Subject: RE: Y/39/20/RES - Land at Street Buildings

Subject: Y/39/20/RES - Land at Street Buildings

Title:
PLANNING LAYOUT

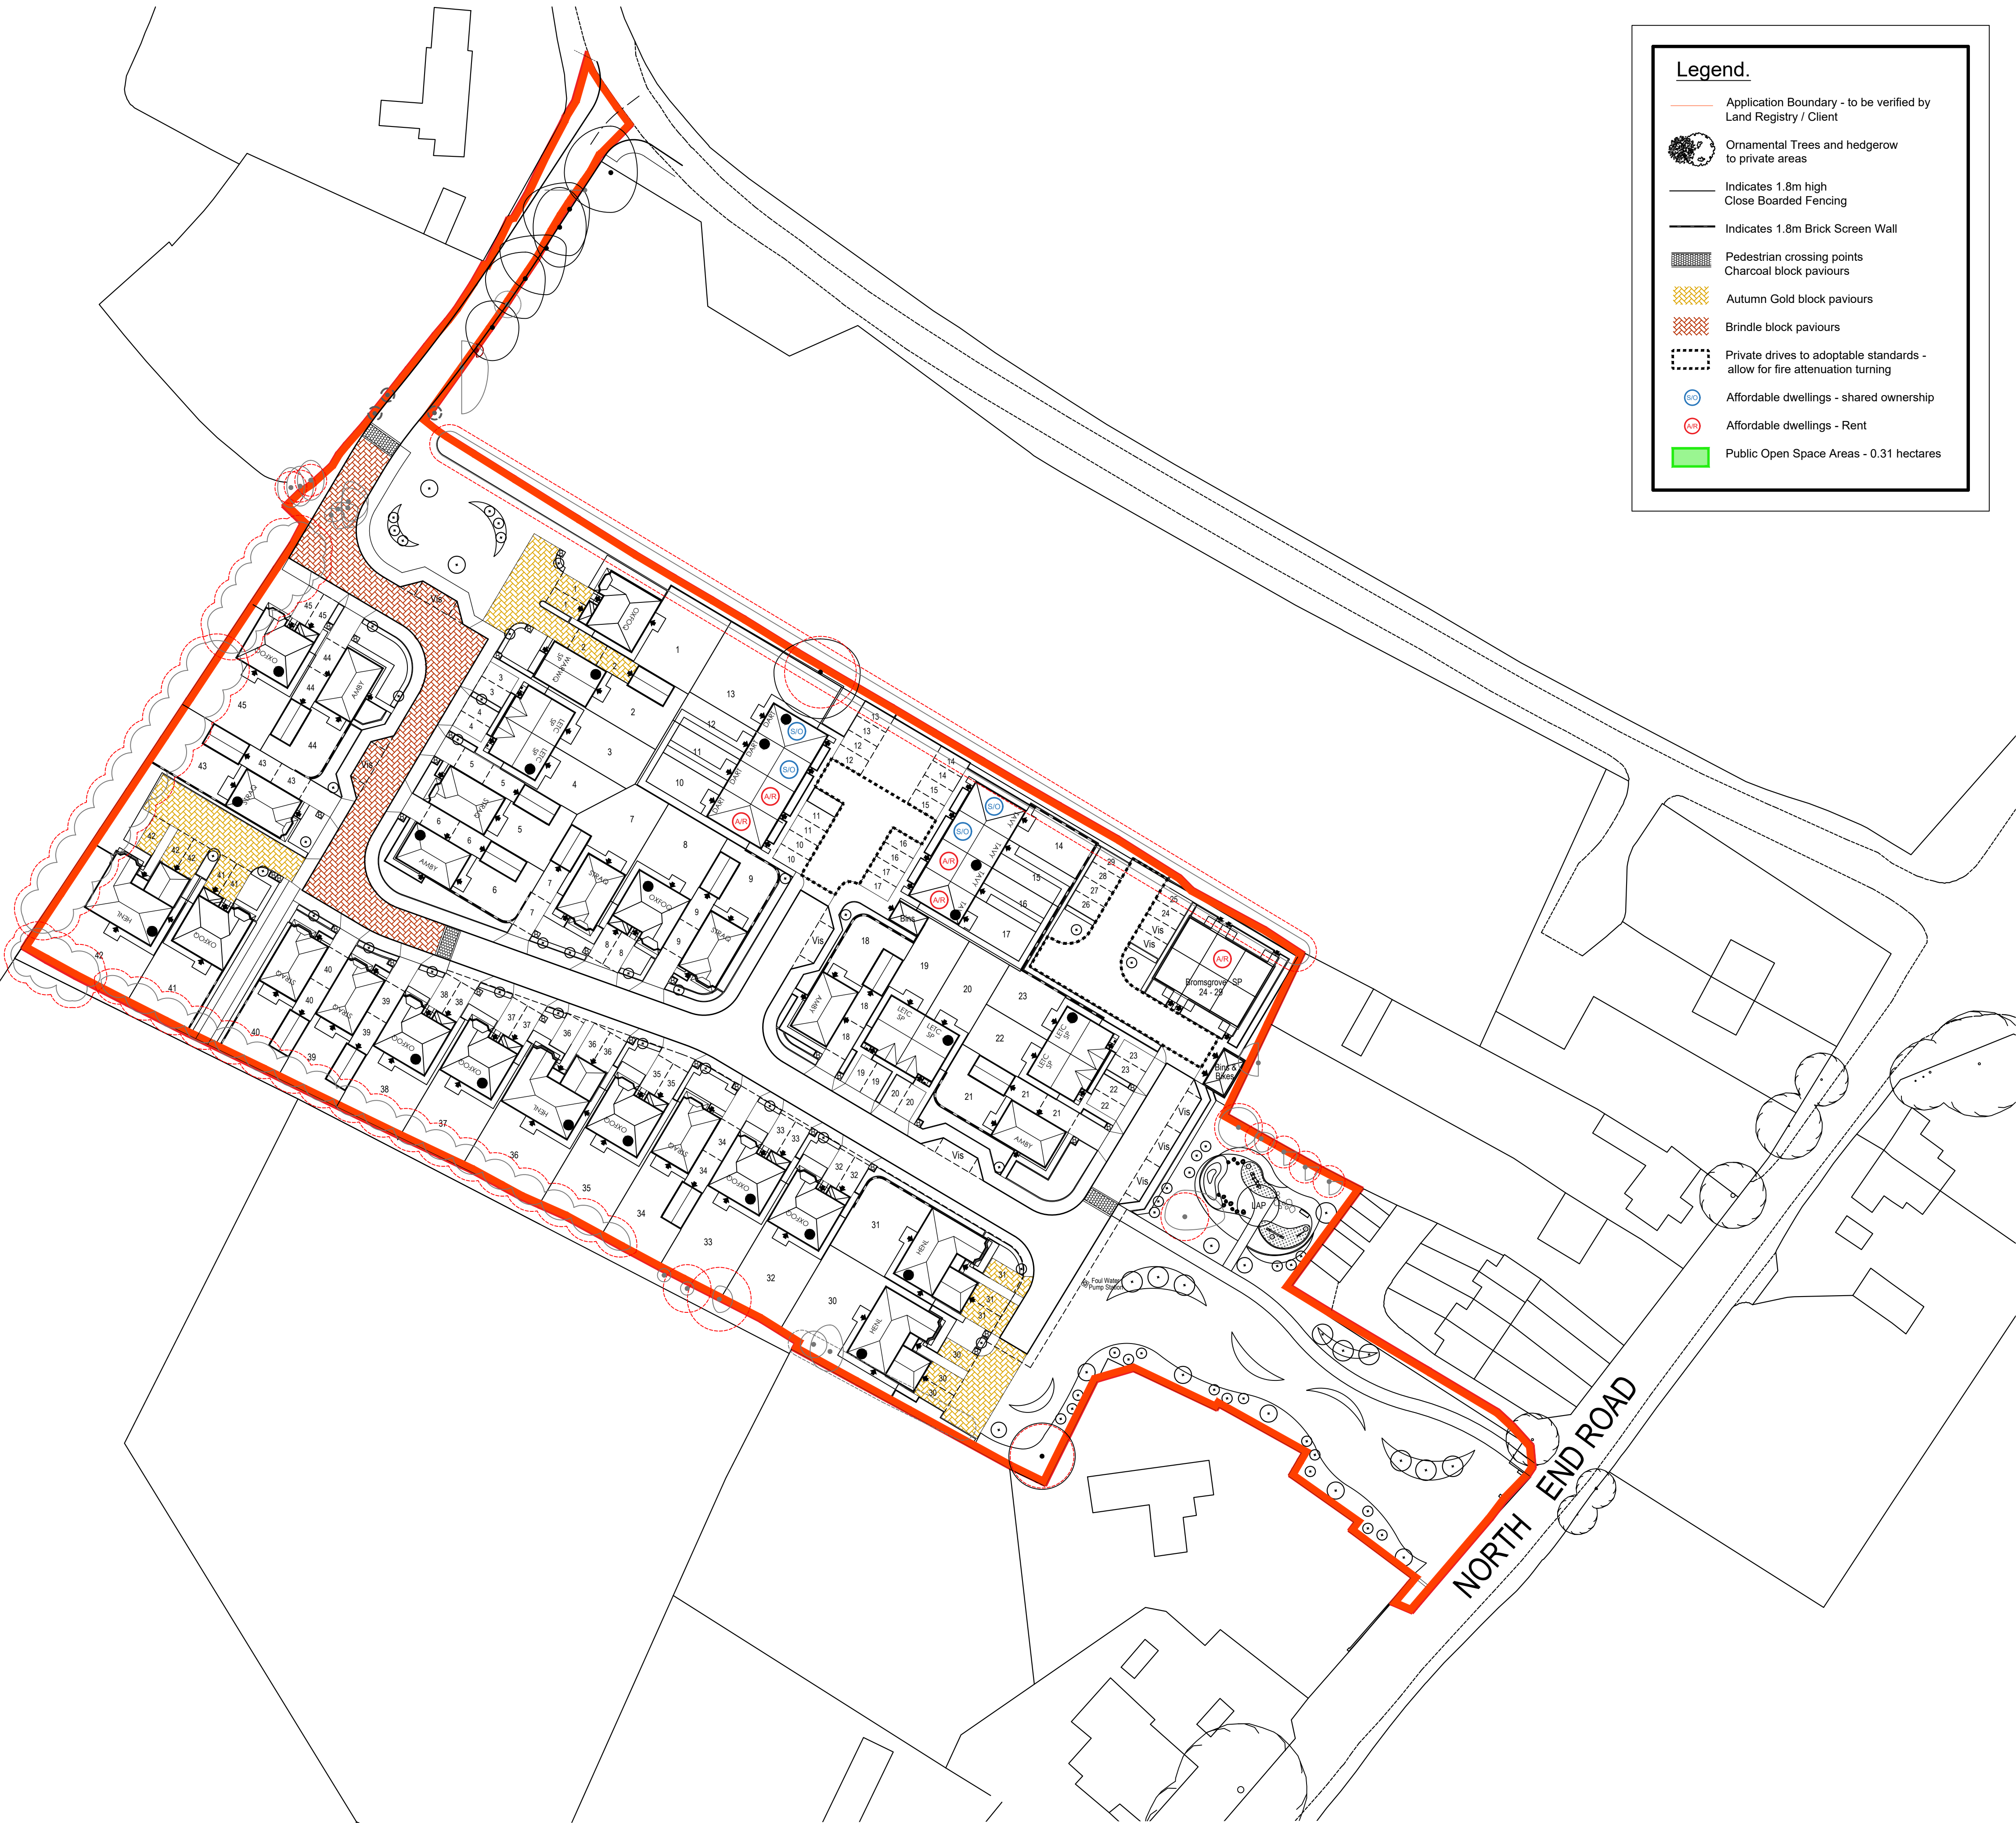
Parking-The LHA would request the parking is demonstrated in line with the WSCC parking standards August 2019, the LHA would request confirmation that the parking allocation has been undertaken in accordance with the latest parking standards."

Please can you respond, however please demonstrate versus the newer Arun Parking Standards SPD available on this page: <https://www.arun.gov.uk/supplementary-planning-documents-spds#parking>
